Recommendation Report for Planning Permission for Works or Extension to a Dwelling

REF NO: BE/115/21/HH

LOCATION: 19 South Way
Bersted
PO21 5HB

PROPOSAL: Loft conversion to form new 2nd floor with roof alterations to form gable end.

sheet 1 of 3

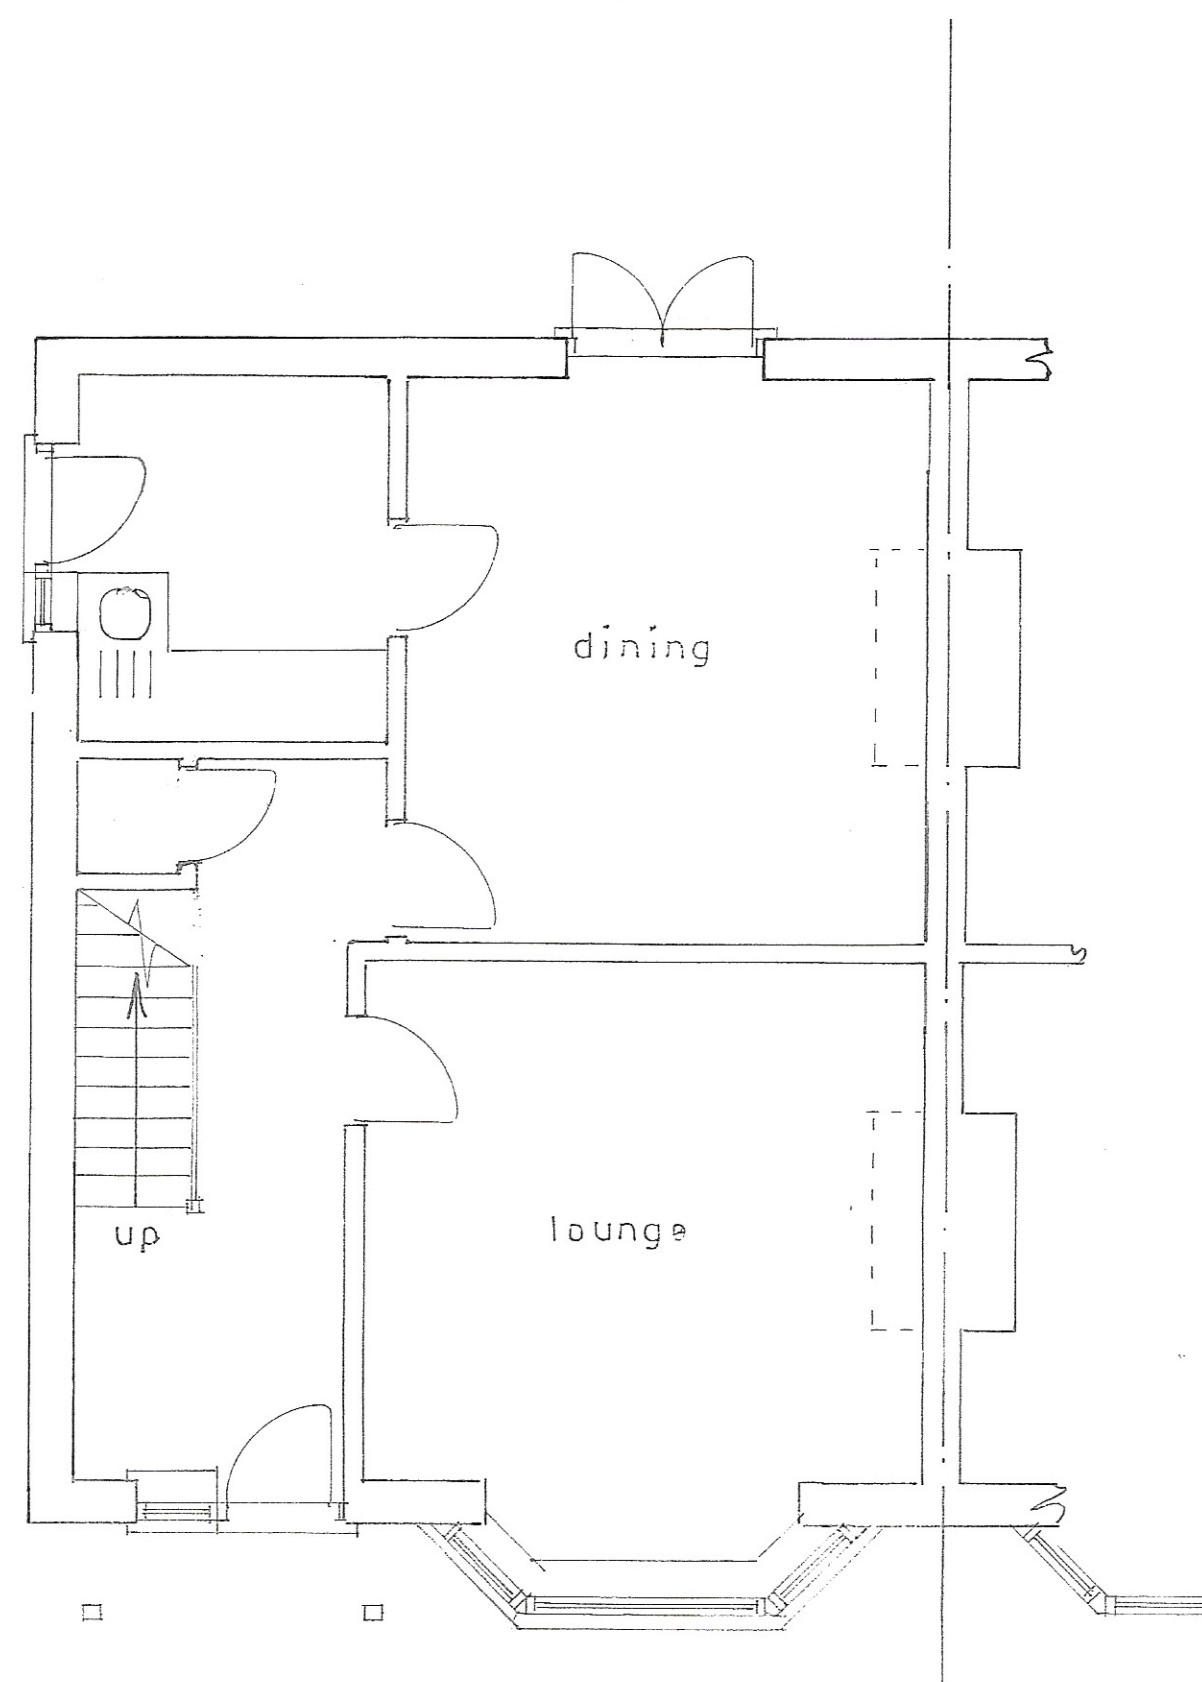
The application also seeks to remove single storey extensions to side (north) and rear (east) elevations and conservatory to rear (east). There will be one new door and window to side (north) elevation and one new double door to rear (east) elevation facing garden.

Due to one new door and window to side (north) elevation there is increased risk to overlooking to neighbouring property number 17 to north however due to being at single storey the existing boundary fence to north restricts views and gap of around 2.77m to north boundary there is no adverse harm to overlooking to north so is acceptable.

Due to new double doors to rear (east) elevation to replace existing conservatory to east there is no increase to overlooking effects to rear (east) so is acceptable.

sheet 2 a of 3

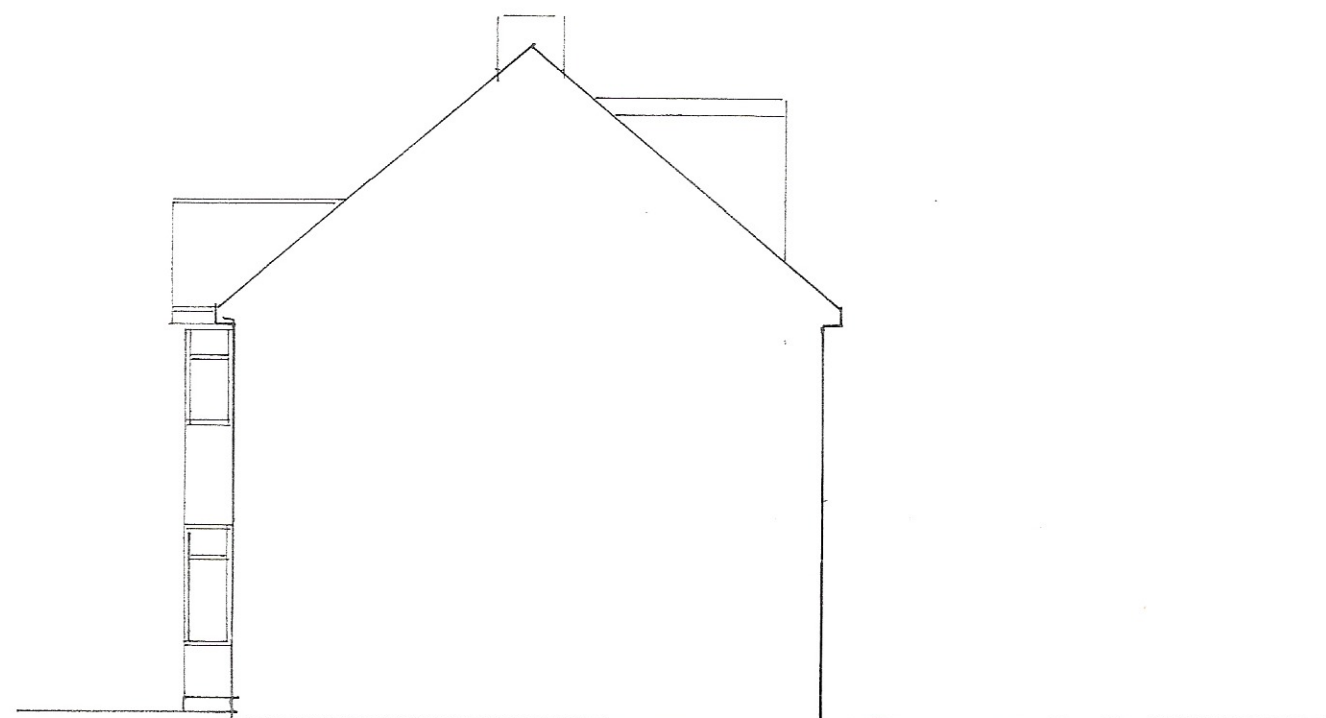
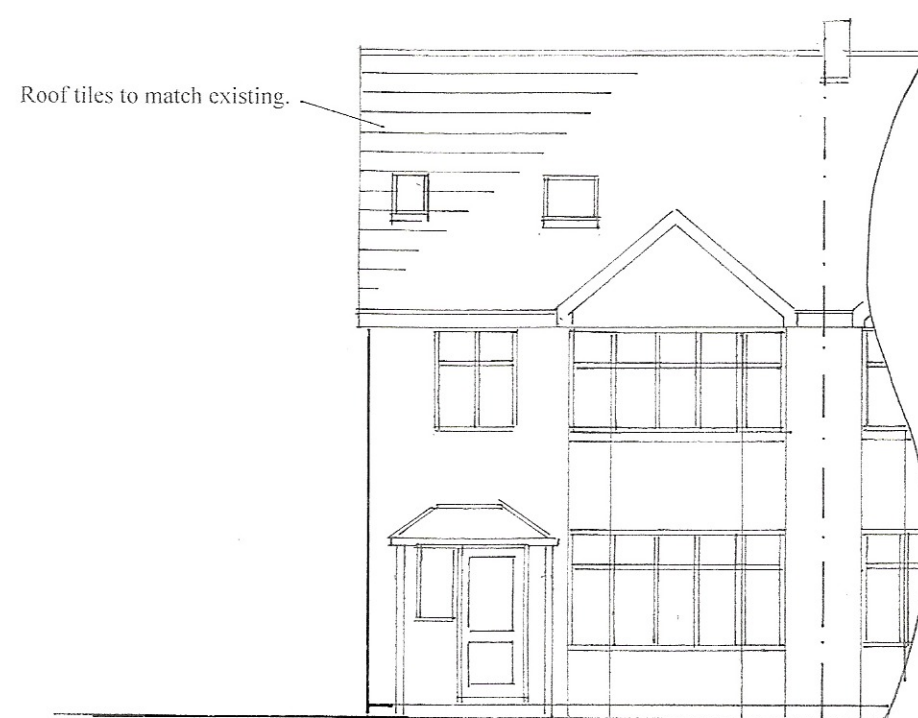
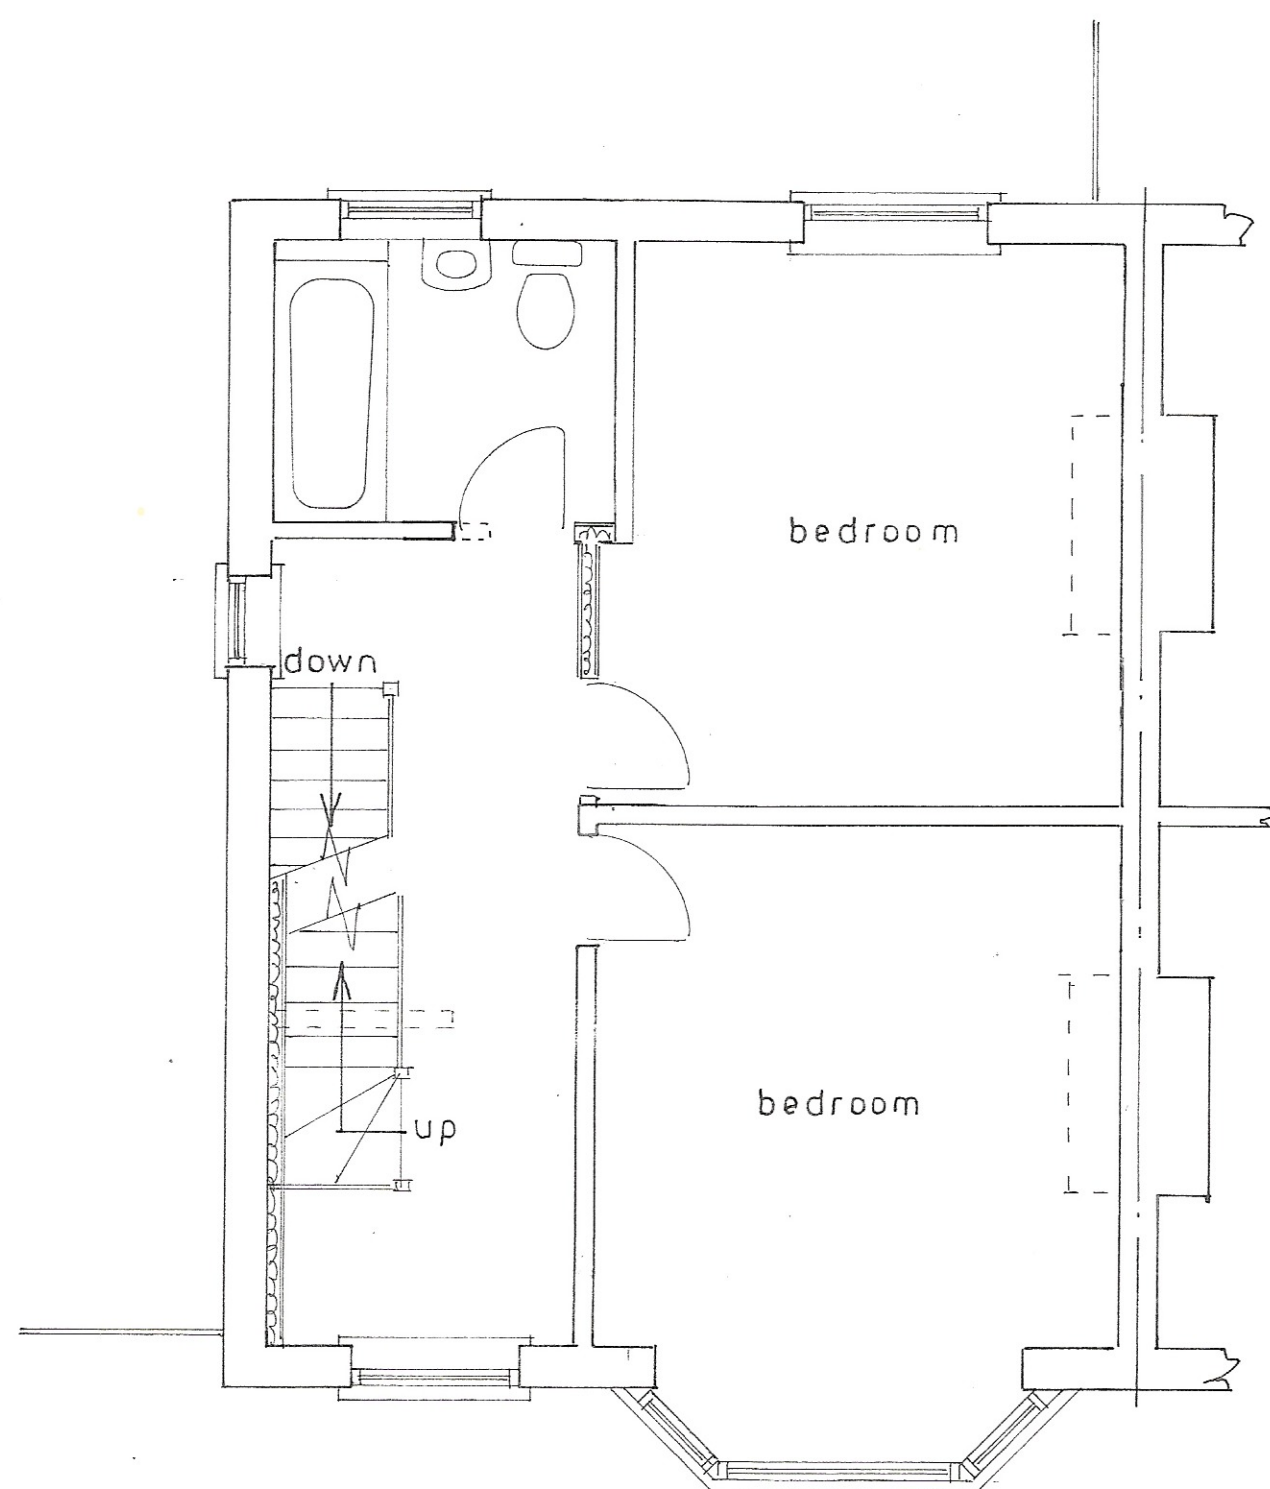
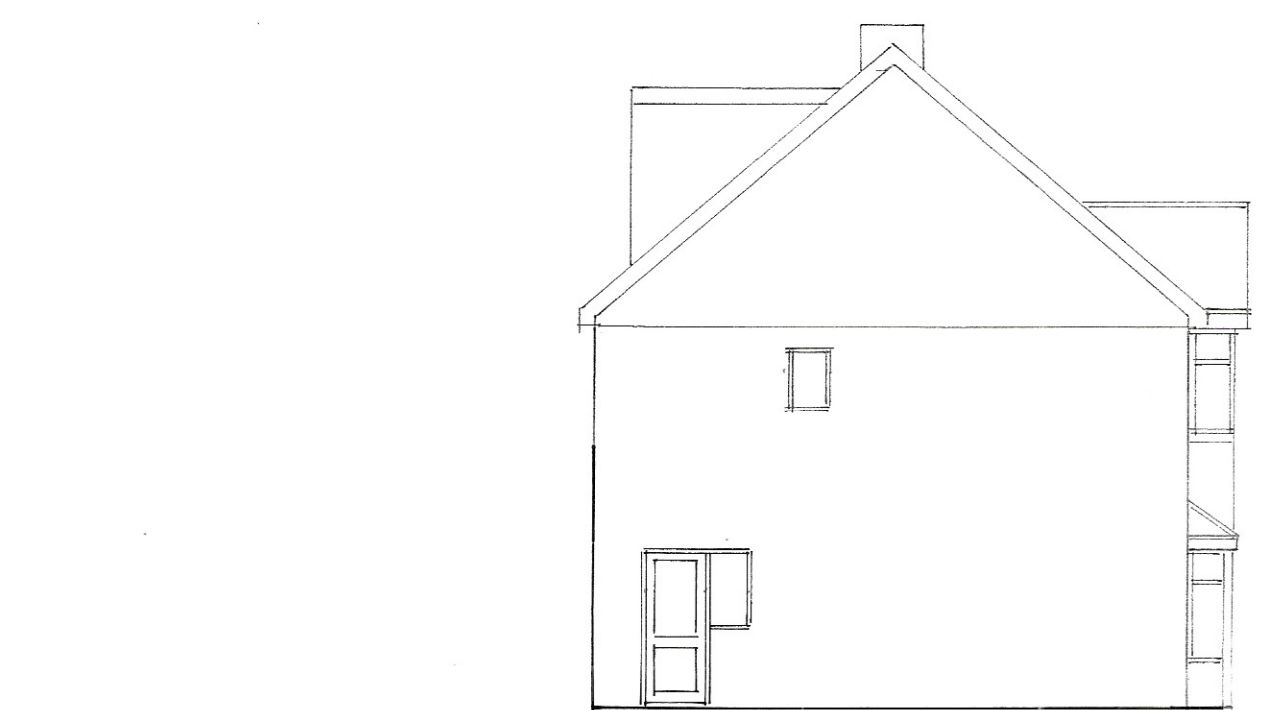
The proposed roof alterations to form gable end will extend north beyond roof ridge line by around 3.77m in length and approximately 3.64m in height (from roof eave to ridge) and are to be of similar materials to match existing. There will also be two new Velux style roof windows to front (west) roof plane.

The proposed loft conversion to form 2nd floor with roof alterations to form gable end will be highly visible from street scene due to being at front (west) roof plane. The roof alterations will add some bulk to front of property. However the roof extension follows at same ridge height as existing building roof and the pitch of roof angle forming gable end integrates with main dwelling roof angle so does not unacceptably harm the character of the area and so complies with D DM1 and D DM4 of the Arun Local Plan.

The proposed loft conversion will also include a new dormer window to rear (east) roof plane. Due to siting at rear (east) of property it is less visible from street scene or surrounding area so does not adversely harm street scene or character of area so complies with D DM1 of the Arun Local Plan.

The rear dormer will have a width of approximately 5.70m and a depth of approximately 2.56m. The height to top of flat roof will be approximately 2.34m. There will one new window (3 window panes) and one new window (1 window pane) to rear dormer elevation facing garden to rear (east).

Due to siting of the proposed roof alterations to front (west) and side (north) roof plane there increased risk of overbearing or overshadowing effects to neighbouring property number 17 South Way to north however due to gap of around 3.25m remaining to north boundary and gap of around 4.40m between the extension and the neighbouring building there is no adverse harm to overbearing or overshadowing effects to neighbouring property to north.

Due to two new Velux style roof windows to front (west) roof plane there is increased risk to overlooking to neighbouring properties to west however due to gap of around 3.57m to front boundary and location of road there is no adverse harm to overlooking to neighbouring properties to west.

Due to the new proposed dormer to rear (east) there is some risk of overshadowing or overbearing effect to north however a gap of around 3.30m to side (north) boundary there is no adverse harm caused.

Due to the two new windows in dormer (3 window panes and 1 window pane) there is increased risk to overlooking to neighbouring properties to side (north) however due to neighbouring property to north set back there is no adverse harm to overlooking to north.

Due to the positioning of the dormer there is increased risk to overlooking to neighbouring property number 21 to south however due to the siting of dormer behind building line to south there is no adverse impact to overlooking to south so is acceptable.
